November 20, 1987

Re: Phase III--Final Developed Conditions Report of the Restudy
 of AMDS Volume II.

- LEGEND
- STUDY AREA BOUNDARY
 - EXIST. CHANNEL
 - STORM SEWER
 - PUMP STATION
 - OLD CAMPUS DRAW
 - PROPOSED CONC. CHANNEL
 - PROPOSED PIPE
 - EXISTING STORM DRAINAGE FACILITIES
 - PROPOSED IMPROVEMENTS AND
 - SITE MAP

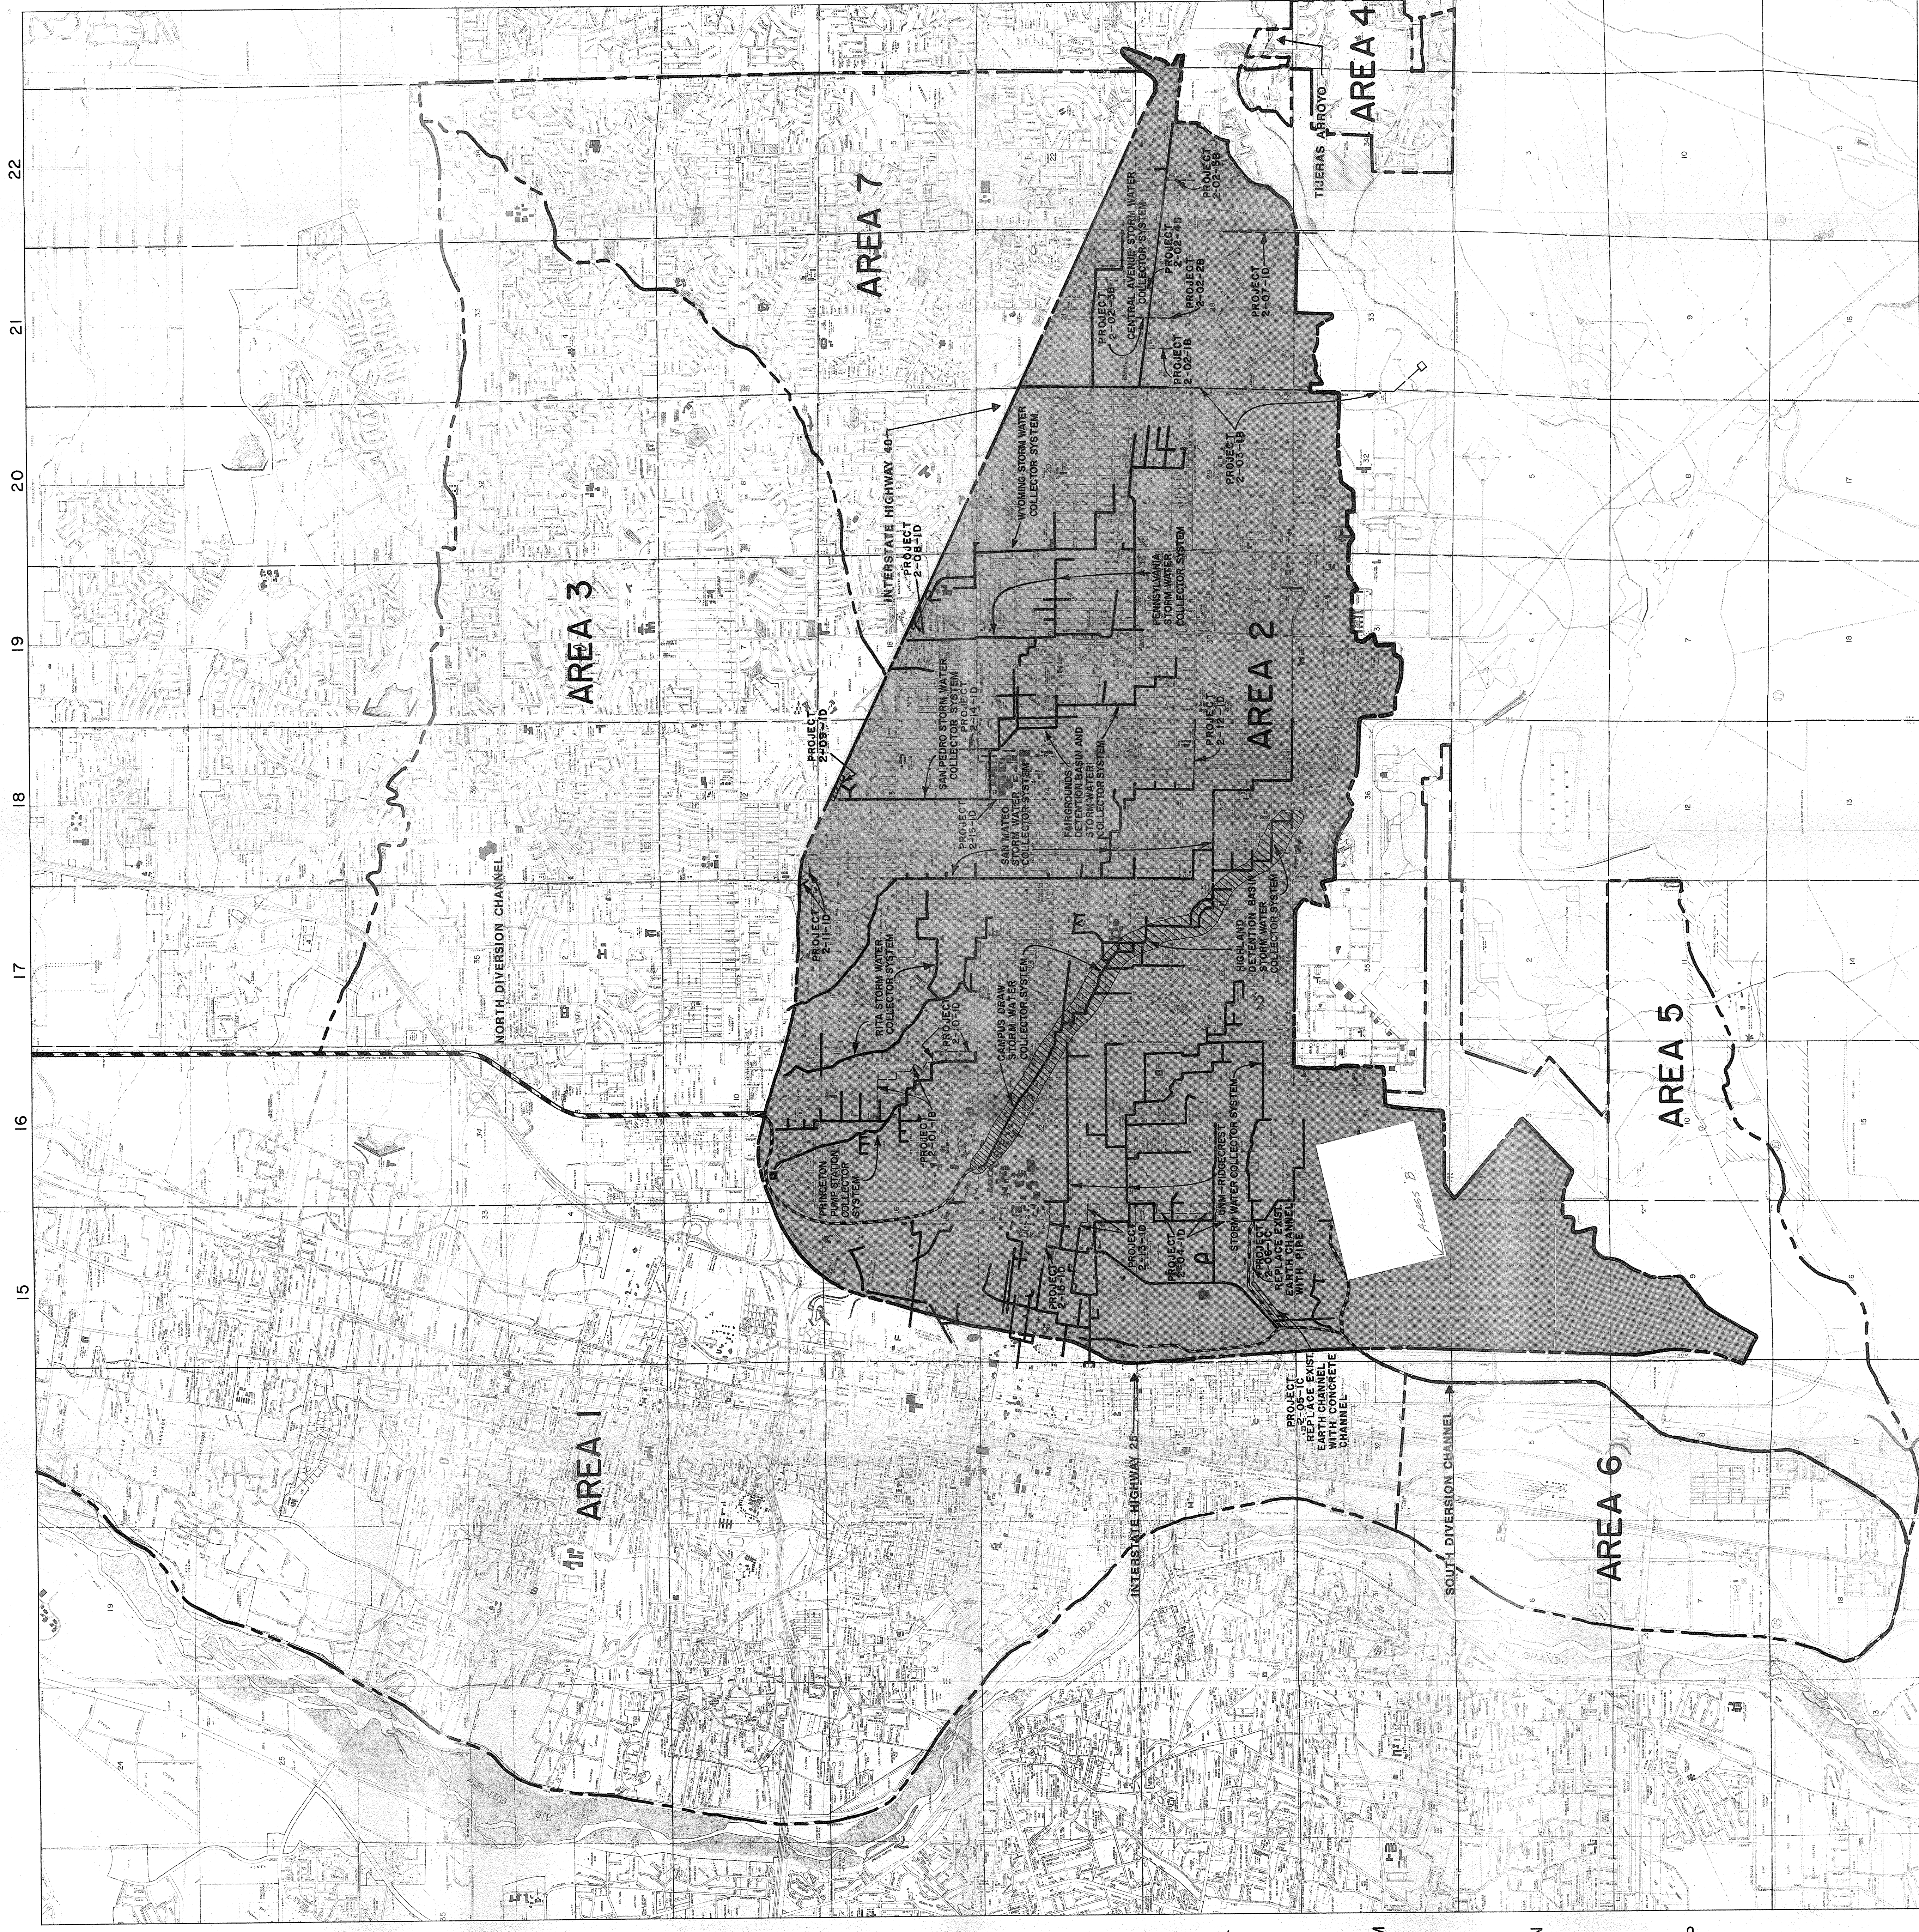
Reference the other AMDS areas with respect to Area 2.

The other areas were placed on Plate 1--Existing Storm Drainage Facilities, Proposed Improvements and Site map.
